Applicant: Bennett

Description: Proposed two storey extension to side/rear of the permanent building to create an additional 1 bedroom dwelling

Site Address: The Permanent Building, Church Street/Regent Street, Barnsley, South Yorkshire, S70 2EH

Title
PROPOSED EXTENSION PLANS

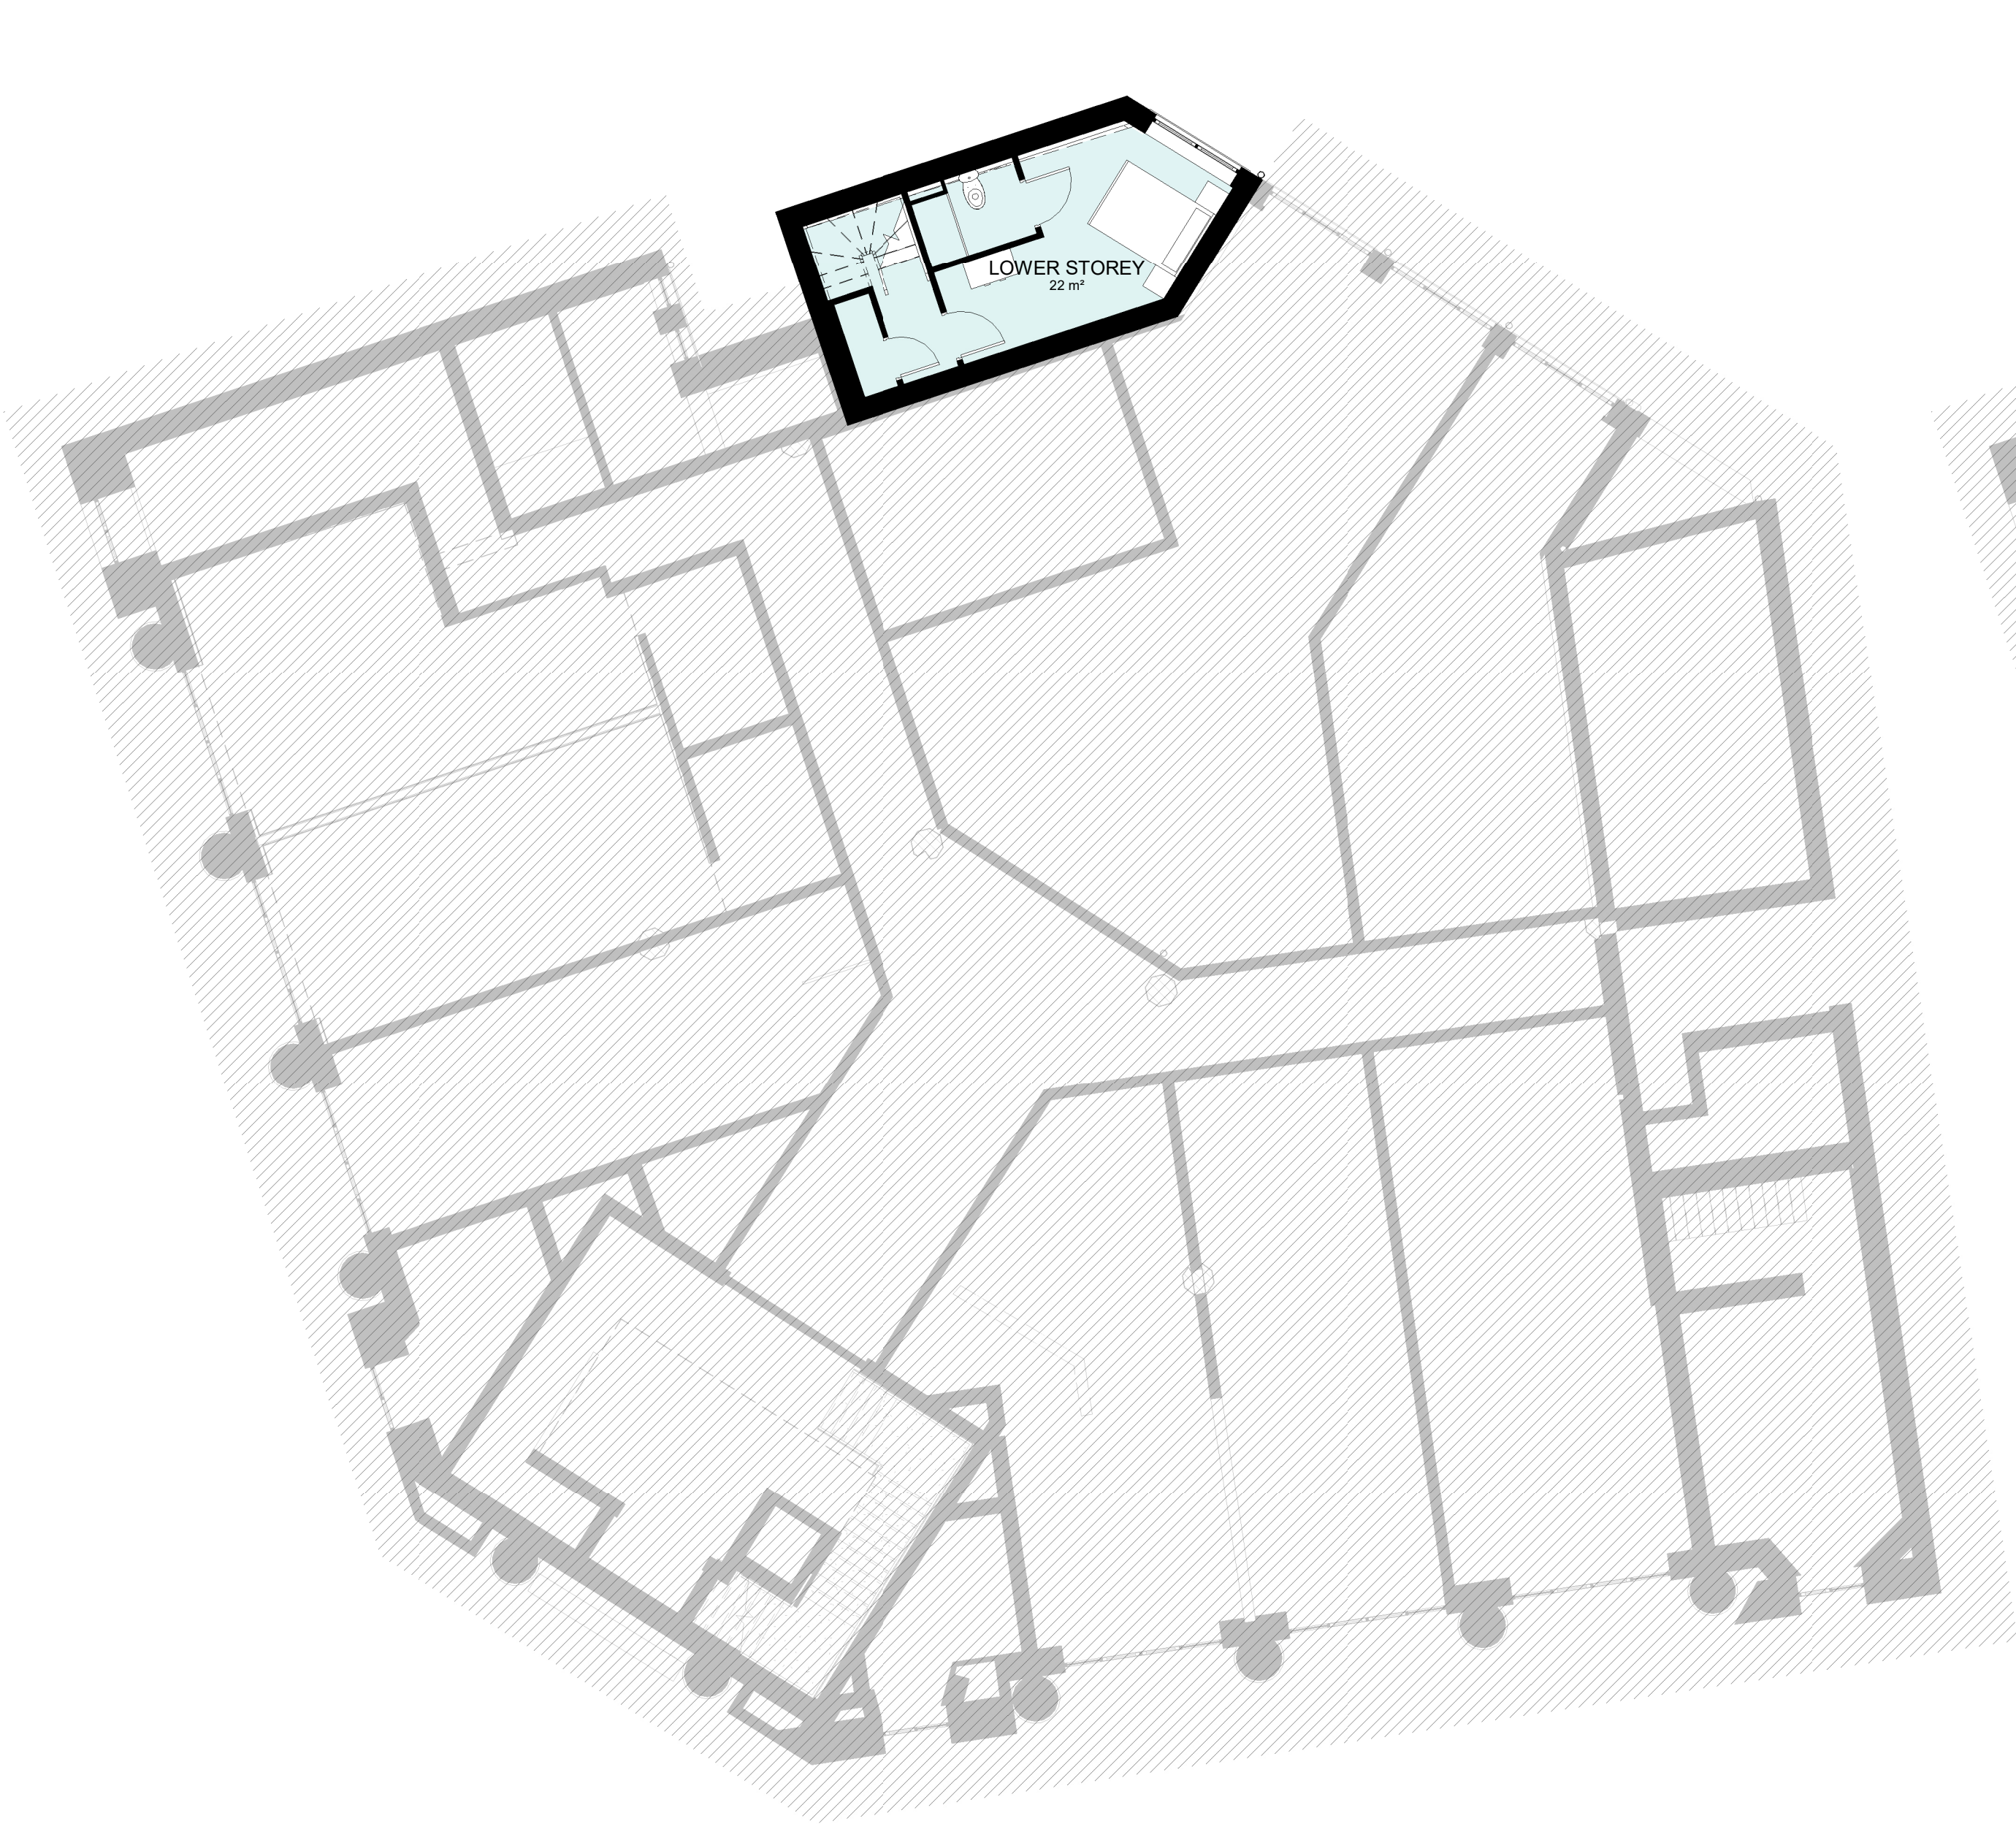
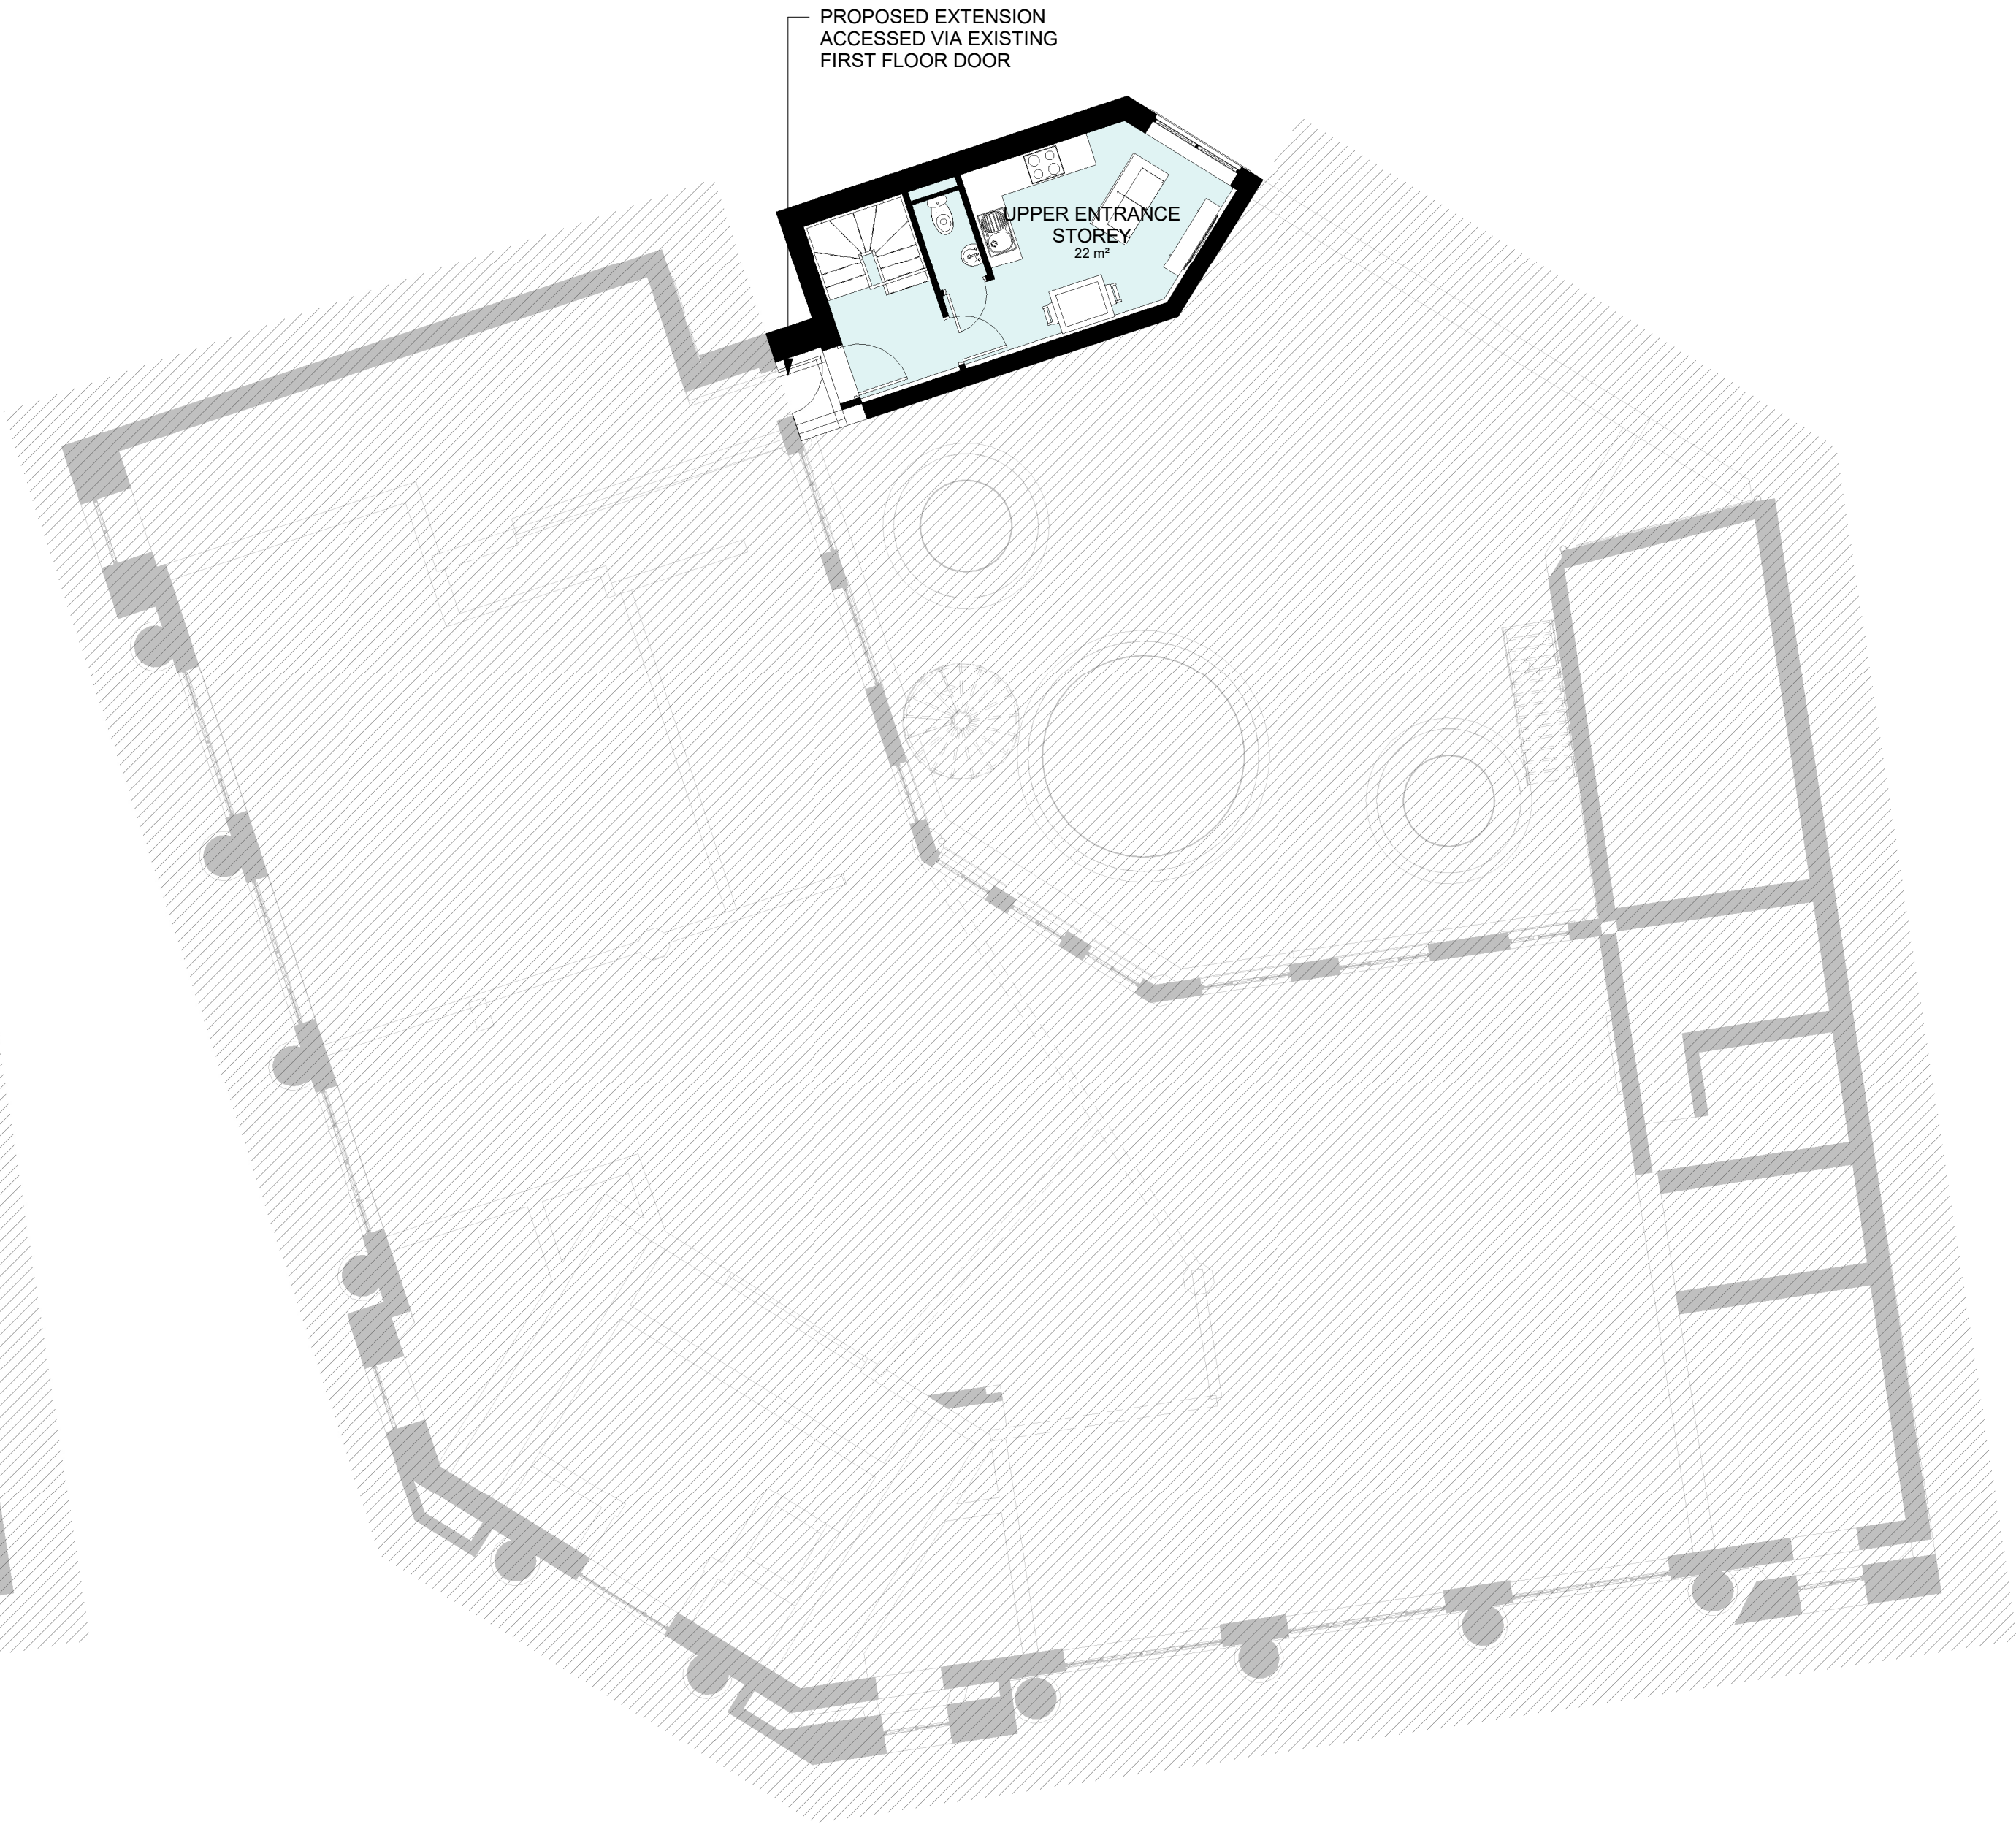
As outlined above, the first and second floors of the building have already been converted to residential apartments and there are units to the rear of the building adjacent to the proposed unit. The upper floor of the proposed apartment would be accessed via an existing corridor and external door at first floor level. The proposed extension would be directly to the rear of unit 11 and would result in some overshadowing and loss of light to that unit, however, the 2no. rear windows serving that apartment accommodate the bathroom which is classed as a non-habitable room and is afforded less protection than habitable room windows. Unit 11 is also split level with the main habitable room being above the proposed extension with the rear windows having views over the extension. The main habitable room is also dual aspect with a window on the front elevation.

It is acknowledged that the proposed apartment is unusual in that it would have accommodation over 2 floors, however it reflects some of the units already within the building, including unit 14 which is immediately adjacent. The accommodation on offer falls 3m² short of the requirement set out in the South Yorkshire Residential Design Guide, however, that is only a 6% shortfall and again is comparable to the existing neighbouring units. The proposed apartment would have adequate accommodation for a single person or couple and incorporates a storage area.

There is a good sized window proposed on each level of the apartment providing adequate levels of light and outlook. It is noted that the windows would be North facing and adjacent to the neighbouring building which projects beyond the proposed rear elevation, however, it would be comparable to the neighbouring units with habitable room windows on the same elevation.

Title
PROPOSED EXTENSION ELEVATIONS

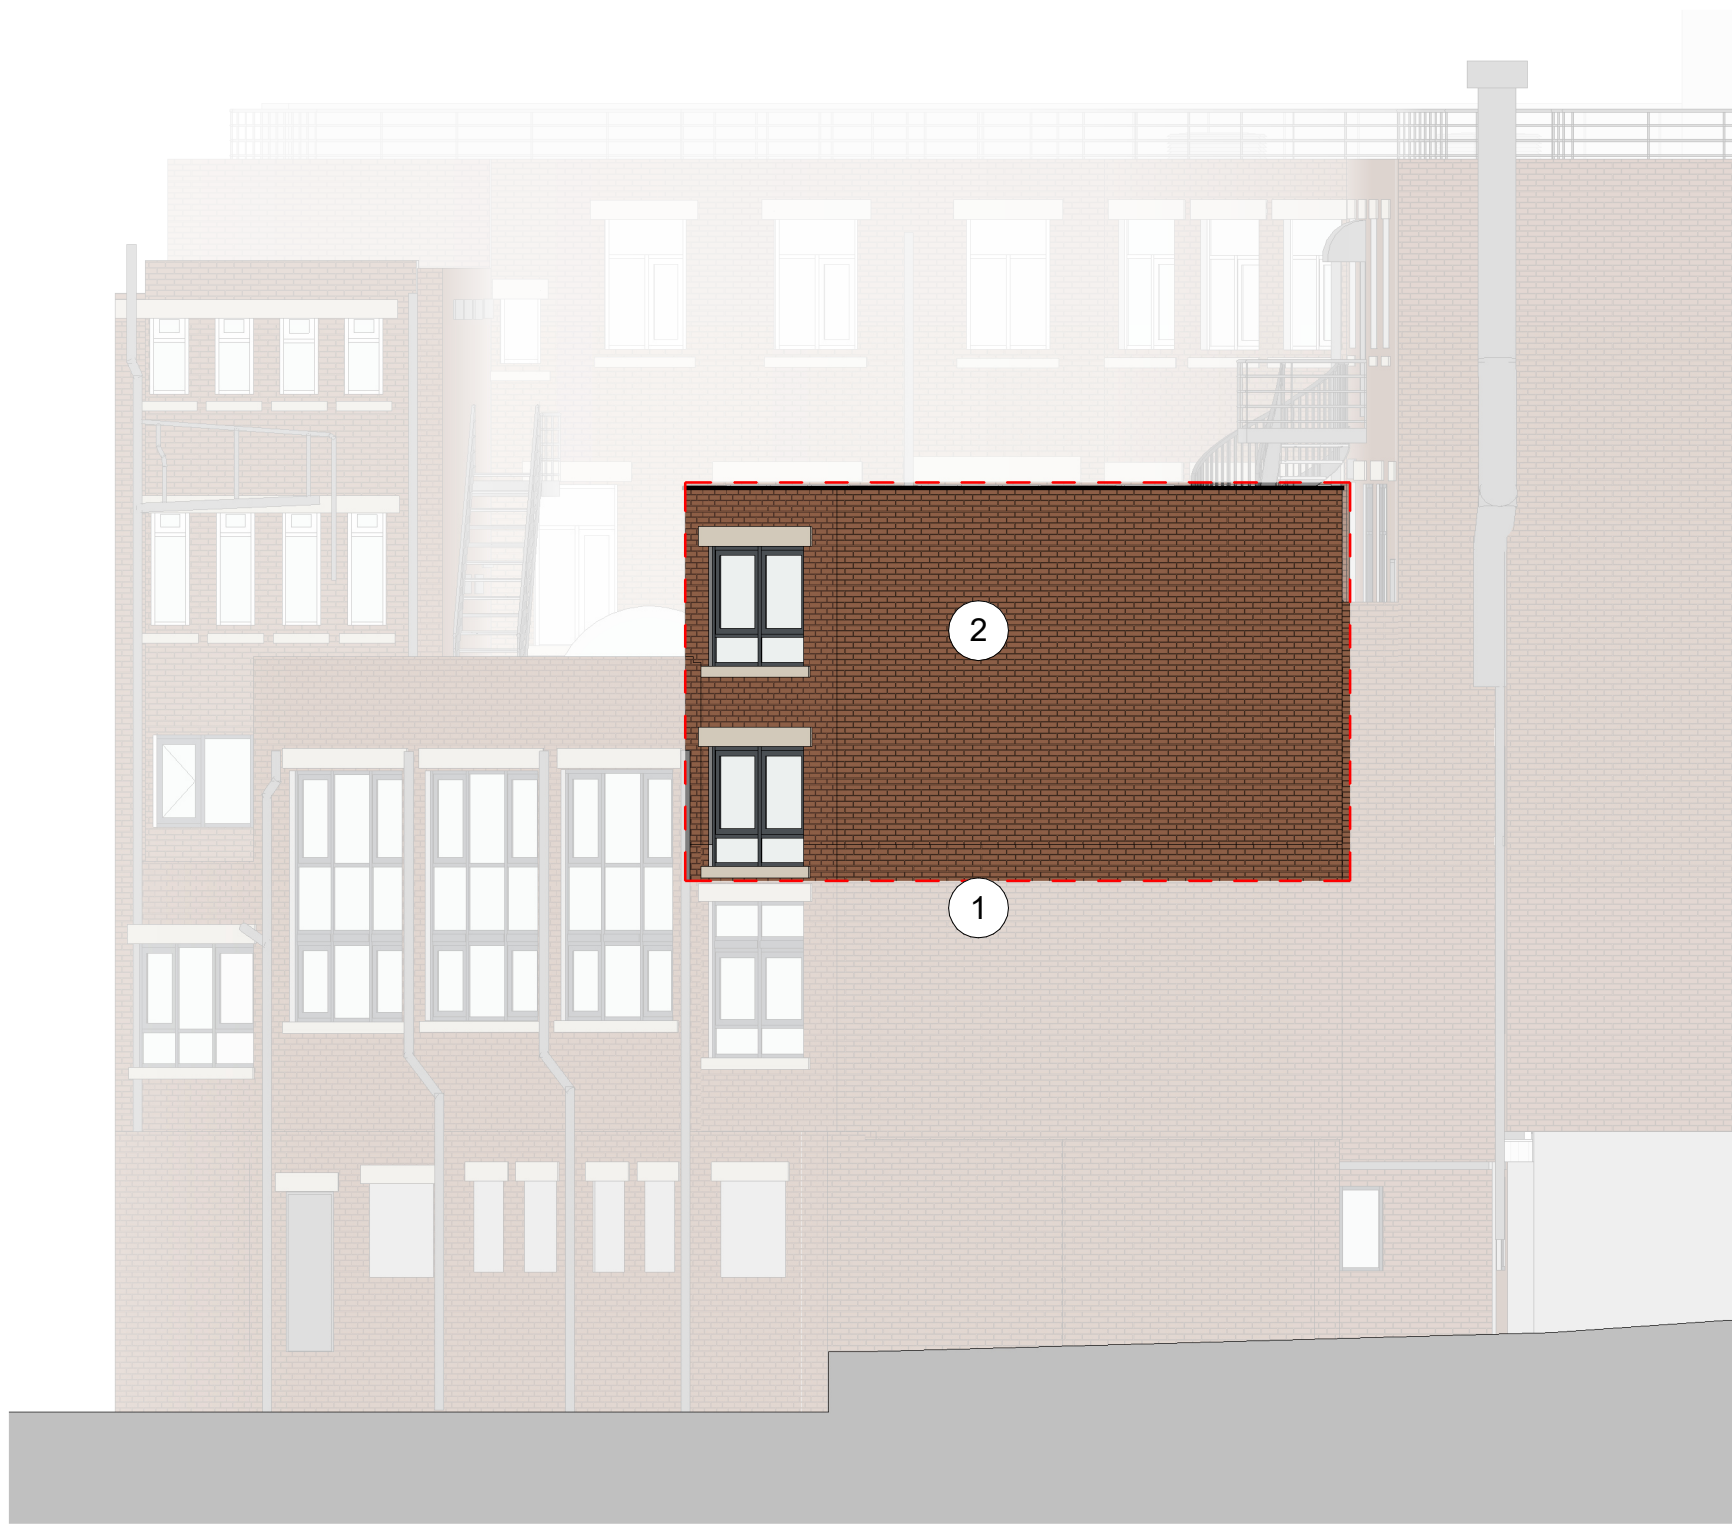
However, the main architectural interest stems from the principal elevations fronting Regent Street and Church Street, with the secondary and rear elevations providing only a minor contribution being away from the public realm and largely not visible. The application seeks permission to provide a single extra apartment / 1 bed dwelling to the rear. The new unit is over a flat roofed area at FFL and will provide accommodation over two floors. Given the low degree of visibility, general lack of contribution and sensitivity, and the matching materials and design there would be no harm to the character of the building or the visual amenity of the Conservation Area and streetscene, in accordance with Local Plan Policies HE1, HE3 and D1.

The proposed extension would also be adjacent to the rear elevation of plot 15 which has its habitable room windows on the rear elevation and is located on the first floor. Given the extension would project beyond the rear elevation of plot 15 and be within 45 degrees, some overshadowing would occur. However, plot 15 has 3no. rear habitable room windows serving a single room and the extension would be orientated to the North. The neighbouring building to the North also projects higher and further than the

There are a number of units at second floor level with habitable room windows on the rear elevation, however, the flat roof of the extension would be at first floor level and those windows would have views out over that roof, as such, it would not significantly impact light or outlook for the residents of the first floor.
